Department for  
Business, Energy  
& Industrial Strategy

16 December 2021

**PLANNING ACT 2008  
APPLICATION FOR A NON-MATERIAL CHANGE TO THE HINKLEY POINT C (NUCLEAR  
GENERATING STATION) ORDER 2013**

Drawing file: EN010001 / EN010001-006701-HPC-NNBPCP-U0-000-DRW-000001 - Plot Plan Rev04 draft v7.pdf

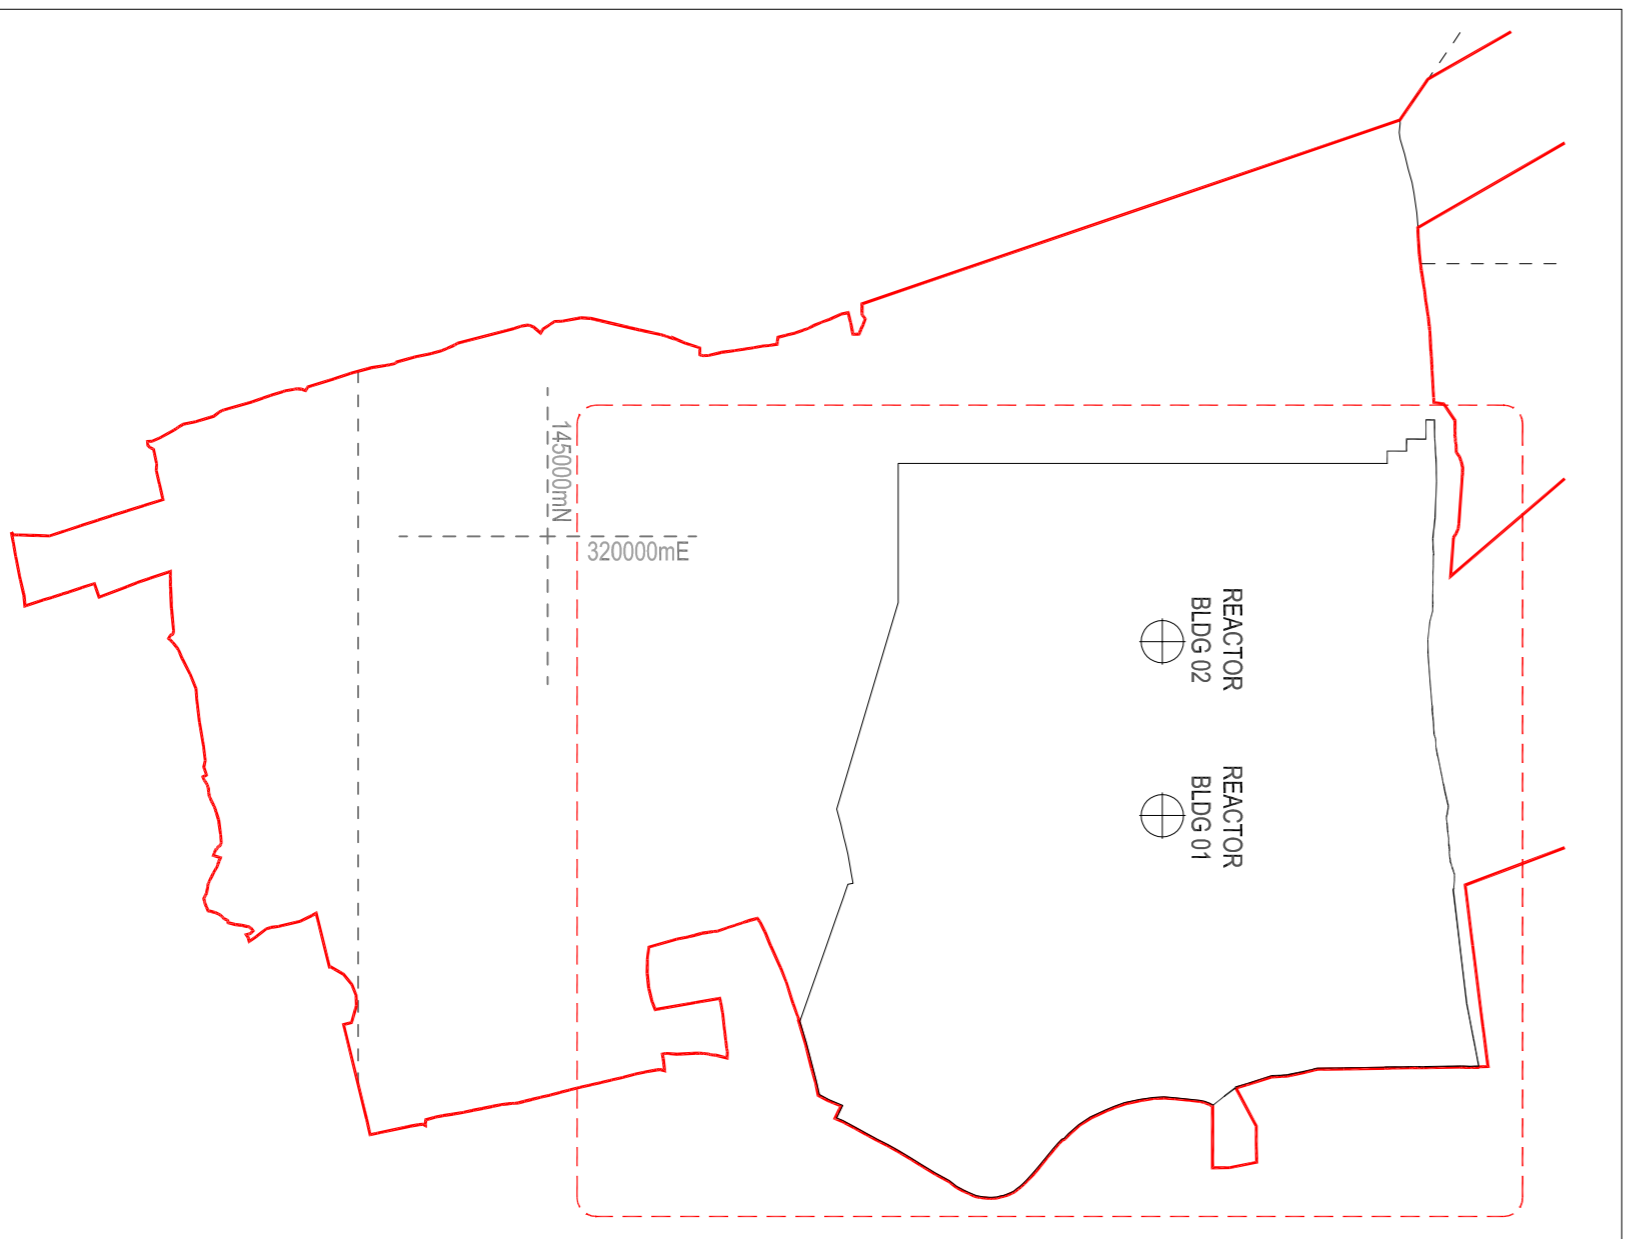
17. SWTC highlighted that the Emergency Response Store did not appear on the proposed Site Layout Plan (REF: HINK-A1-SL-00-GA-010) and requested that this be rectified. Additionally, SWTC questioned whether the location is suitable for the Oil & Grease Storage & Oil Ancillary Building (which would replace the Emergency Response Store) given that it does not meet the highest seismic qualification level.

18. In its response, the Applicant has explained that the Emergency Response Store has been removed and its functions moved into the proposed Back-up Emergency Equipment Store (which is shown as building 59 on the Site Layout Plan). The Applicant also explained that the Oil & Grease Storage & Oil Ancillary Building does not require the highest seismic qualification level as is not associated with the main nuclear safety functions (these are generally: control of reactivity, removal of decay heat in fuel, confinement of radioactive material, or other related functions). Despite not being associated with the main nuclear safety functions, the Applicant asserted that standard design codes will be applied and the building will comply with regulations related to the storage of hazardous substances. The Secretary of State is content that this response suitably addresses the issues raised by SWTC.
